January 18, 2024

SUBJECT: 2915 Robinson Street

2915 W. ROBINSON  
1"=10'  
DOORS ON REAR AND FRONT OF BUILDING

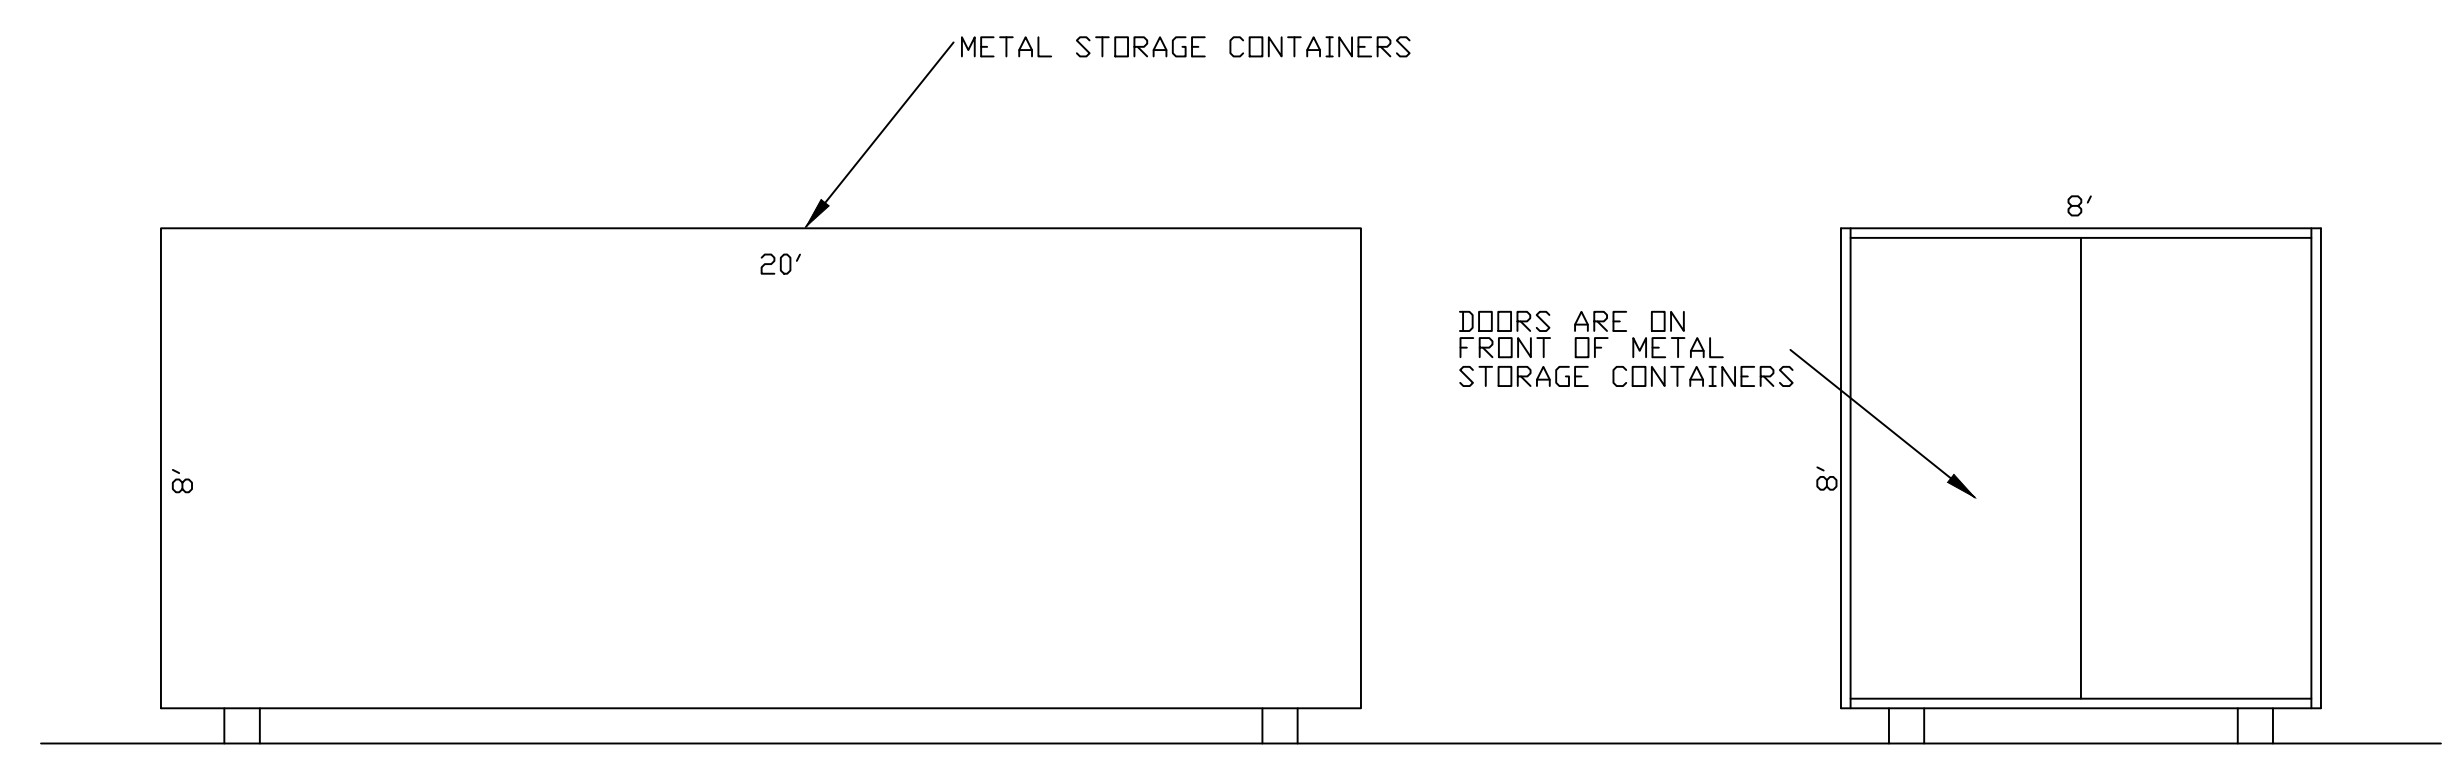
The site plan and aerial imagery show containers inside the platted drainage and utility easement. Storage containers will have to be moved outside of the easement. Please update site development plan showing containers outside of the easement.
